Inner West Council Response: SSD-78268465 – Newington College Redevelopment (Concept and Stage 1)

Property: 200-244 Stanmore Road and 221-235 Stanmore Road, Stanmore

Attachment A - Consolidated Inner West Council Officer comments SSD-78268465 – Newington College Redevelopment (Concept and Stage 1)

Temporary Carpark

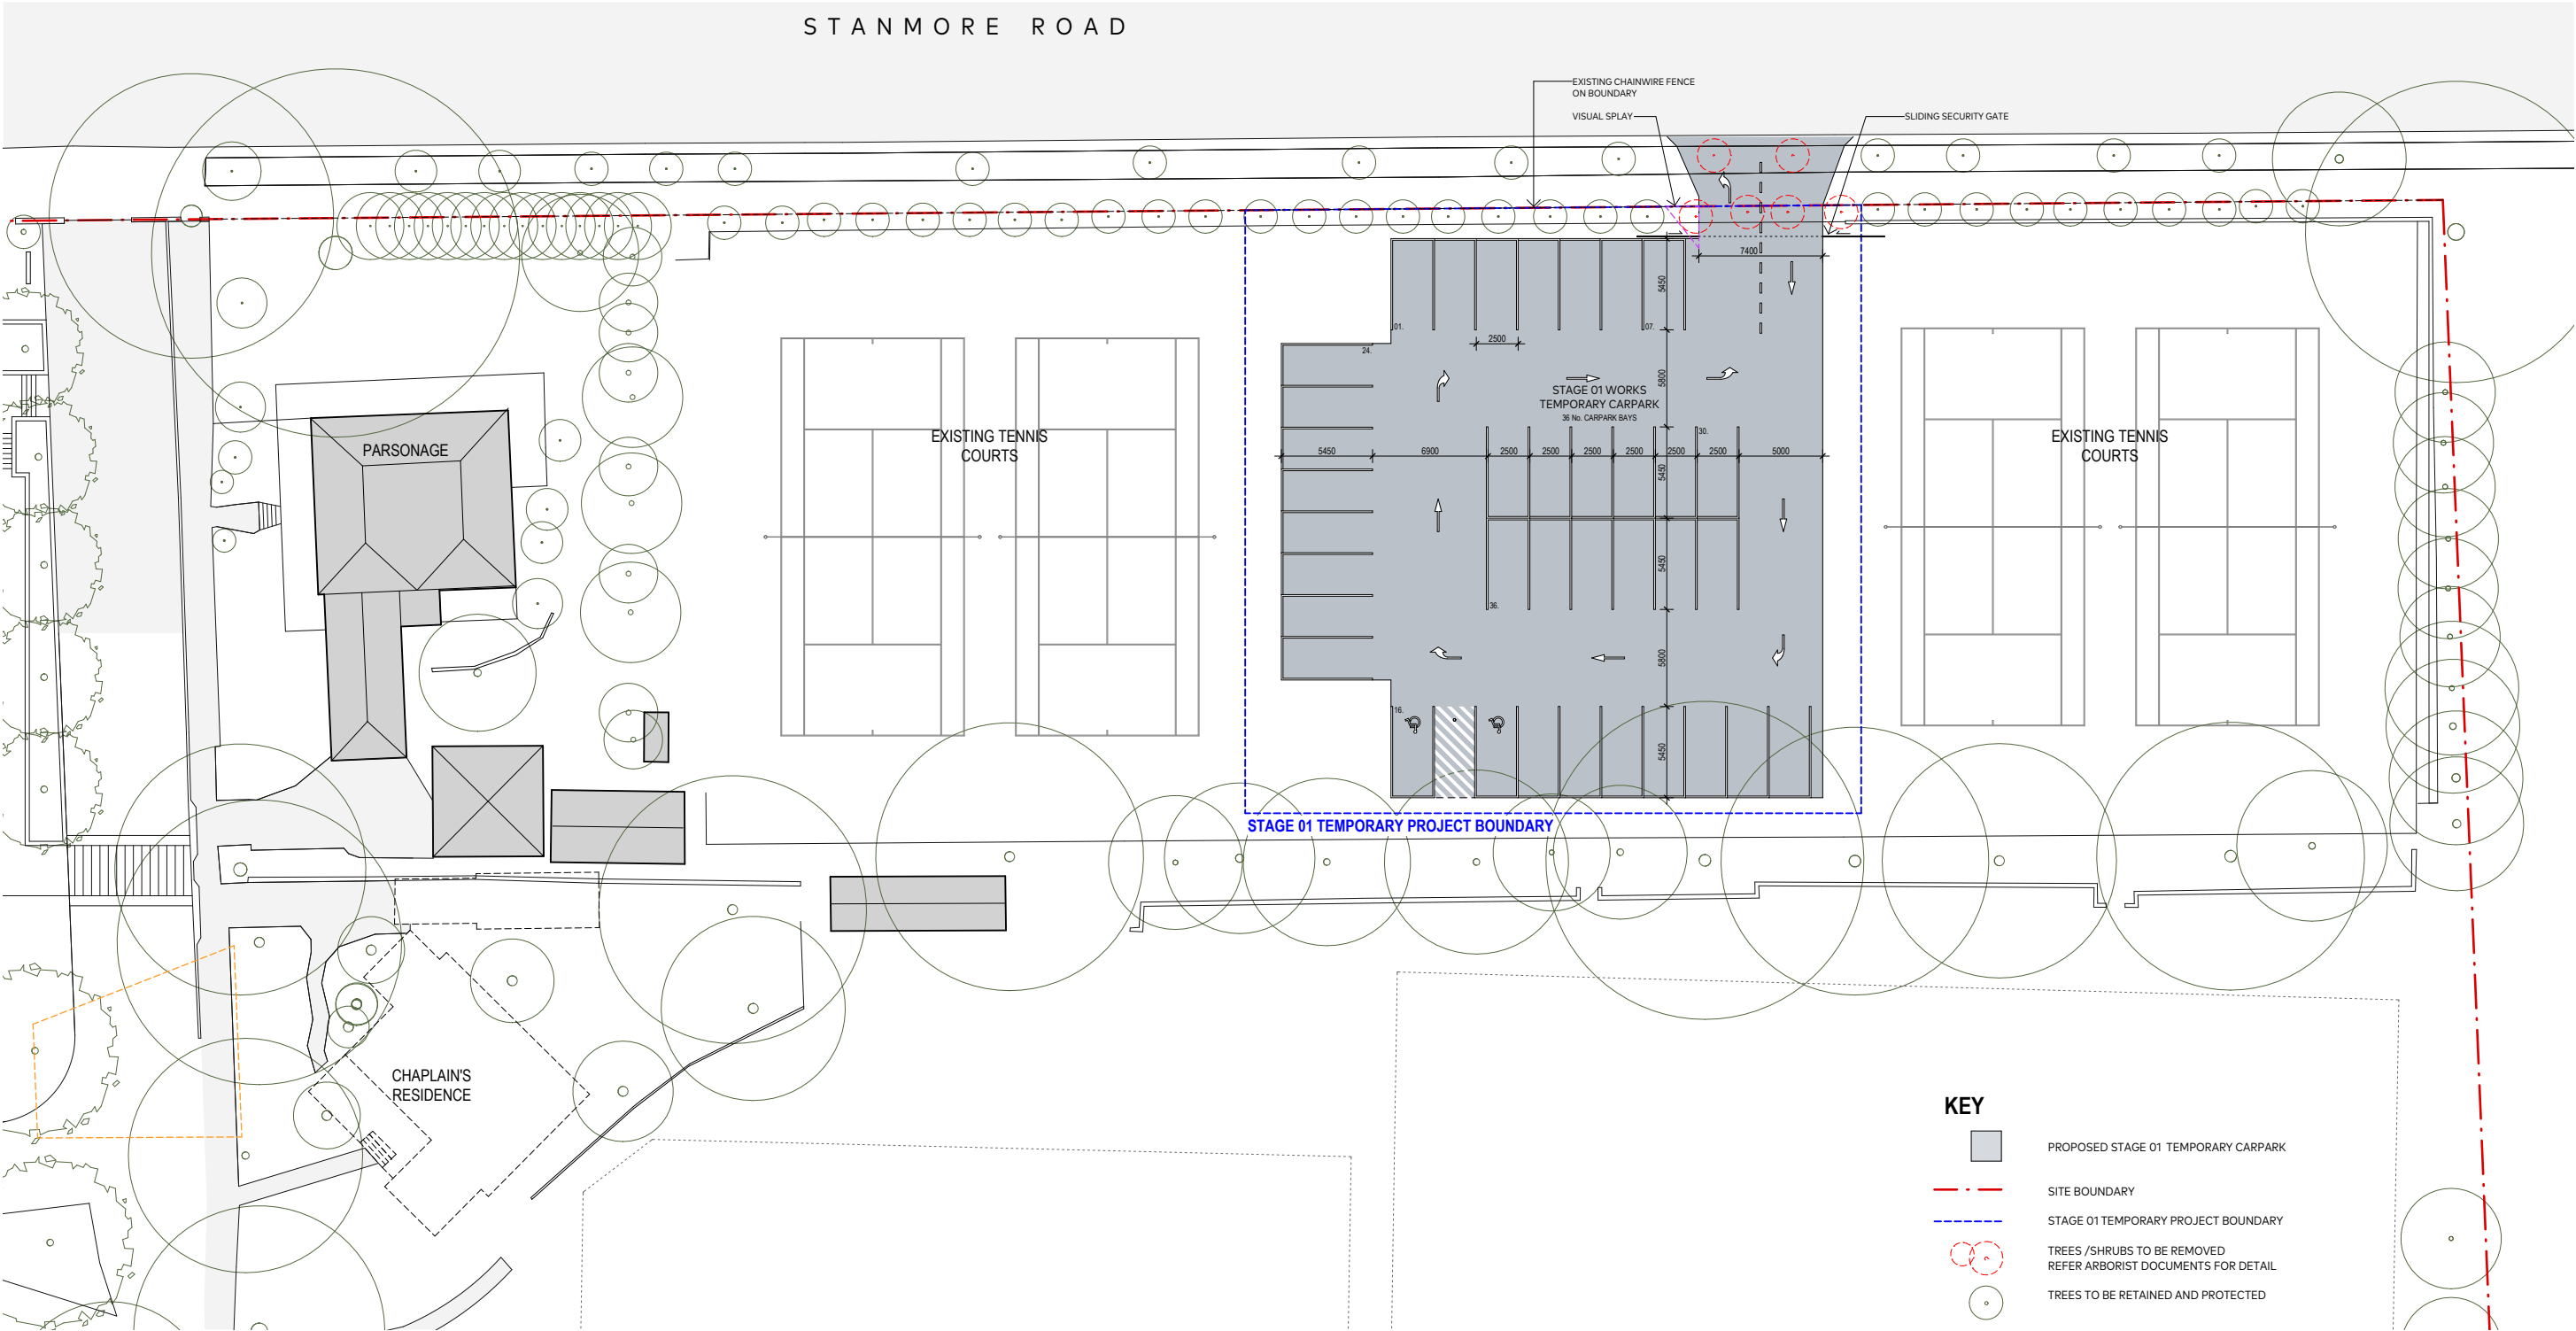
- d) Justification or refinement regarding the height of the roof plant structure on top of the Sevington Building.
- e) Clarification is required regarding the Stage 1 temporary car park and the proposed restoration of the site following completion of Stage 1. In particular, insufficient information has been provided to demonstrate what mechanisms are to be relied upon to ensure the temporary car park will be removed and the tennis courts and landscaping reinstated. Nor have any drawings been provided showing what the reinstated courts, fencing and landscaping will look like. A restoration plan and associated drawings is requested to confirm the final site layout and that a condition is imposed requiring all temporary works (such as the carpark) be removed prior to the occupation of the Sevington Building.

- e) Regarding the Stage 1 temporary car park, Council does not typically support the removal of street trees for temporary vehicle access. However, support may be considered where the proposed tree removal forms part of a broader public domain outcome, including the undergrounding of existing overhead electrical infrastructure on Stanmore Road to facilitate the planting and long-term establishment of larger replacement street trees and an improved tree canopy outcome. Further consideration should be given to locating the vehicular entry and exit point at the same location approved under the 2014 consent to minimise unnecessary tree removal and impacts on existing vegetation.
